**Section 96A of the Town & Country Planning Act 1990 (as amended)
Town and Country Planning (Development Management Procedure) (England) Order 2015 (as amended) -
Article 10**

Application No: EP/132/21/NMA
Site Address: 27A Sea Lane East Preston BN16 1NH
Description of works: Non-material amendment following grant of EP/2/21/HH for the alteration of front balcony and rear Juliet balcony doors from being single doors with windows either side, to double doors.

Elevations (1:100)

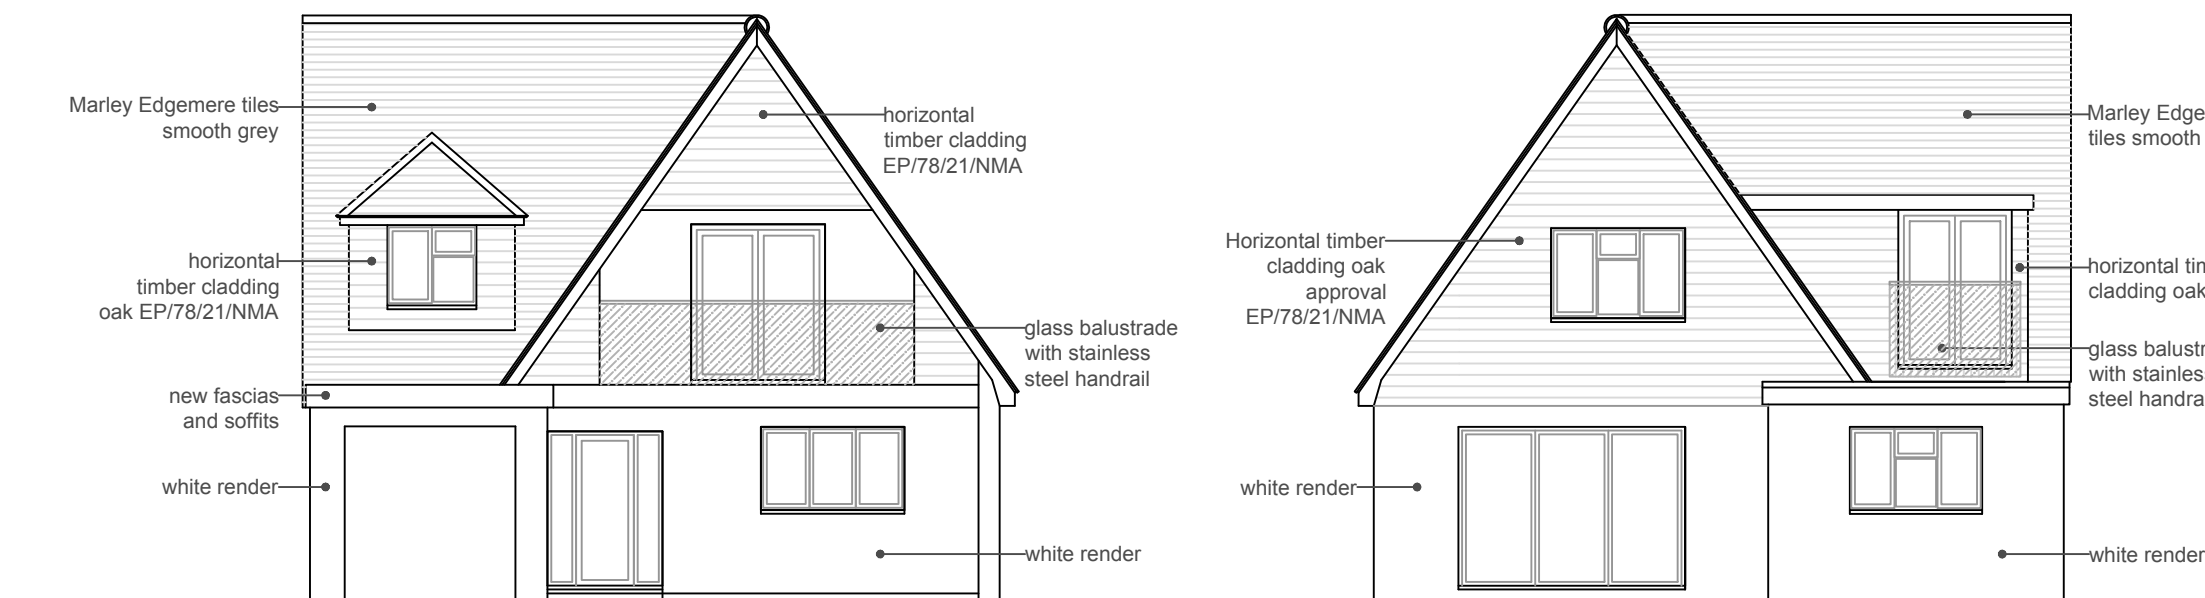
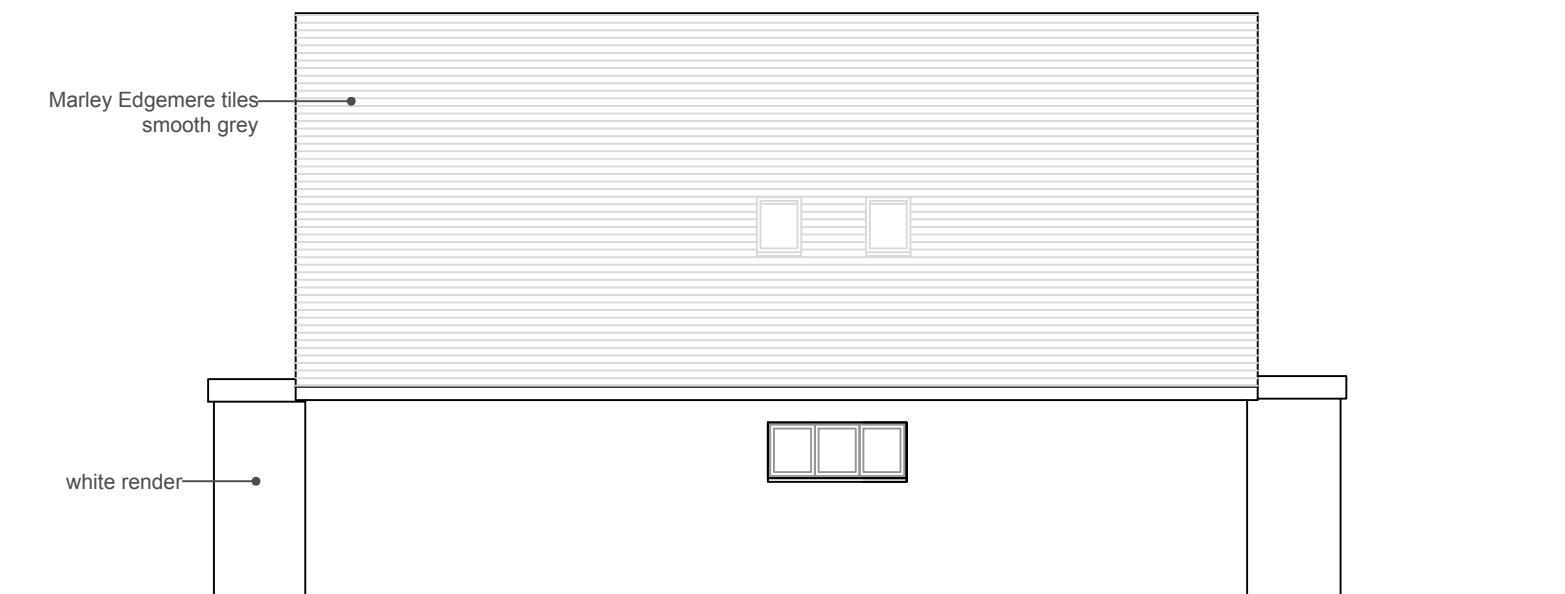
I write as Chairman of the East Preston and Kingston Preservation Society. We are concerned that the changes proposed in this application (which already appear to be being carried out) have been accepted as non-material. The original agreed design on the rear elevations was for a Juliet balcony spanning a single door with small side windows - not the widened one necessitated by double doors. The implications for diminution of privacy and amenity have been outlined by other objectors, but design is also a factor. A single door with small side windows was agreed for both front and rear elevations which provided a variation in line removed by the severely rectangular blocks of fenestration illustrated on these plans. It is regrettable that such bad design can result from what we feel are material changes in the appearance of the building.
